Application number: 2024/93341	
What is the application for?:	Erection of extension to detached garage block, raising of roof height and erect
Address of the site or building:	54, Wellhouse Lane, Mirfield, WF14 0PW
Postcode:

WEST ELEVATION
1:50

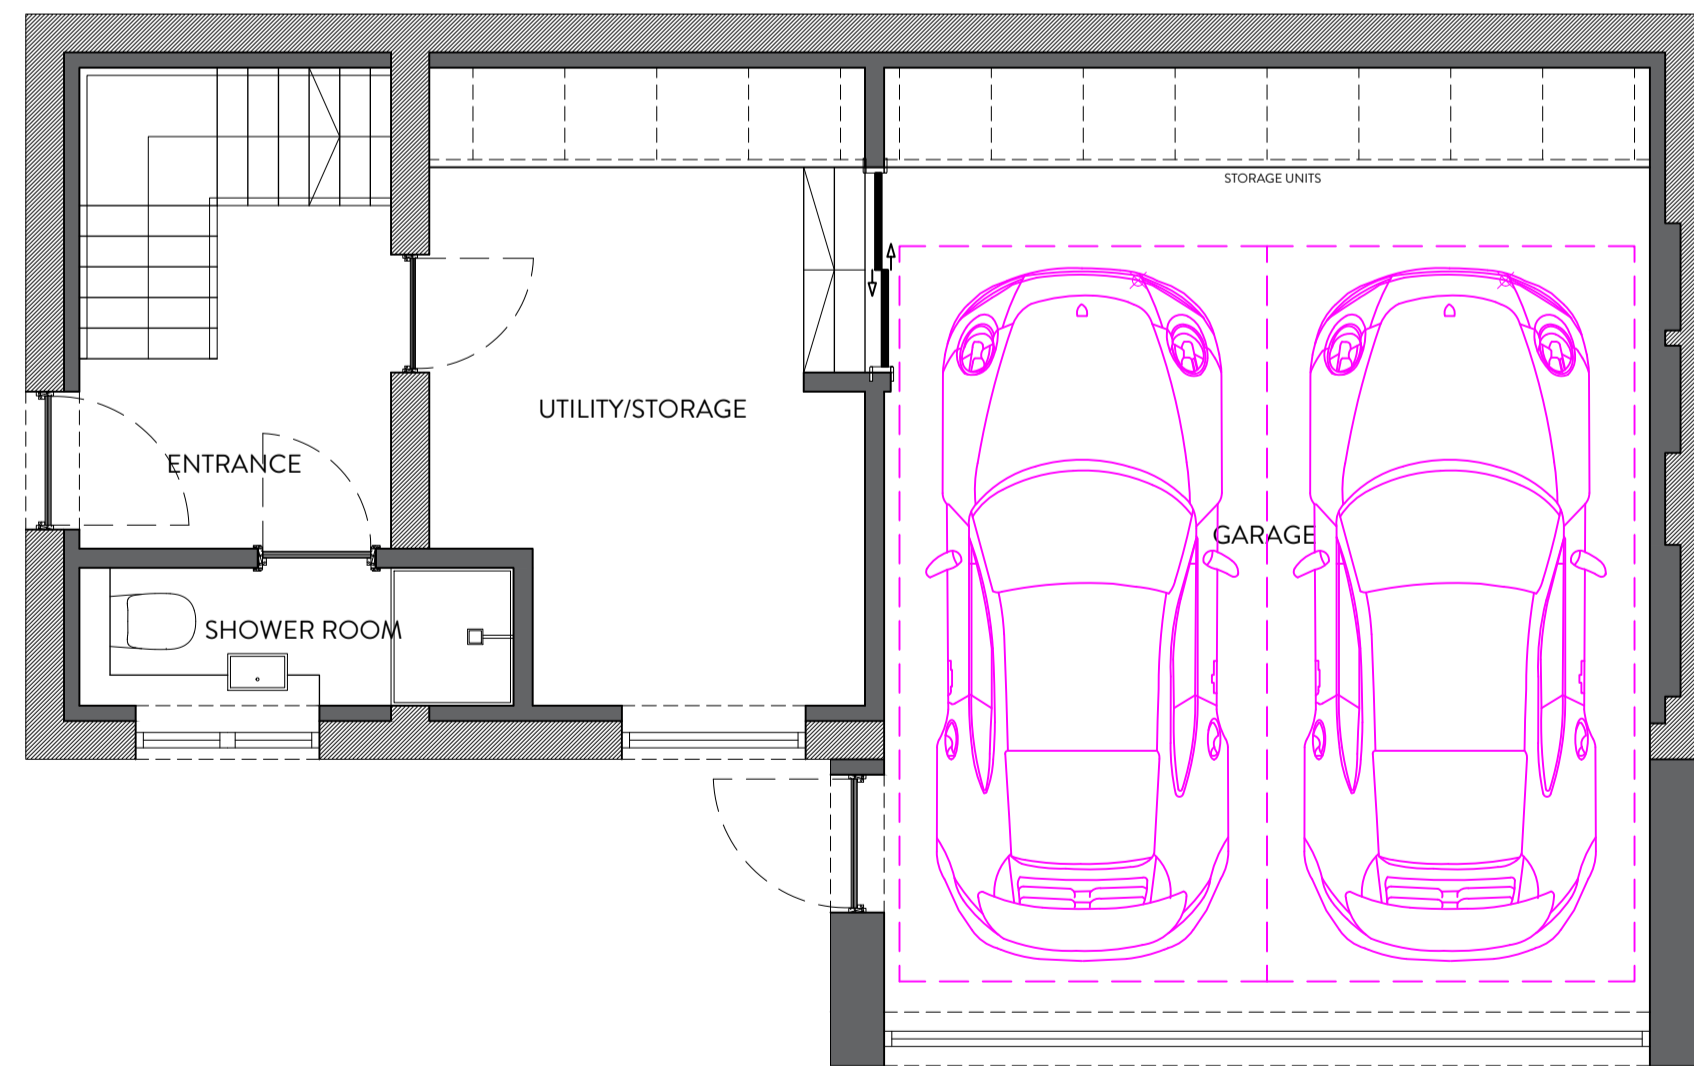
Type of comment: An objection	
Do you wish your comments to be published on the website anonymously?	<input type="checkbox"/> Yes
<p>The ground plan and design plan view (west gable) suggests the existing structure will be demolished and rebuilt.</p> <p>#54A Wellhouse Lane and #6 Woodward Court are objecting to the planning application and will not allow access for building work or scaffold.</p> <p>Does the existing structure have a cavity wall and damp course? Will it need to be demolished to create new foundations in which case the boundary with #54A Wellhouse Lane and #6 Woodward Court would not allow.</p> <p>Without access to #6 Woodward Court how will the builder prevent any debris/building materials from falling into the garden and thus the safety of #6 Woodward Court residents.</p> <p>The structure proposed roof height will increase and block light to number #6 Woodward Court.</p> <p>#52L and #54A Wellhouse Lane have right of access across #54 Wellhouse Lane property. Where would the construction lay-down area be?</p> <p>To maintain vehicle access to #52L and #54A Wellhouse Lane during the construction phase, builder vehicles will have to park on Wellhouse Lane. Creating unnecessary risk at school start and finish times when Wellhouse Lane is severely congested.</p> <p>Longer-term could the owner of the property change it to residential and sell. If that is the case will new services be required?</p>
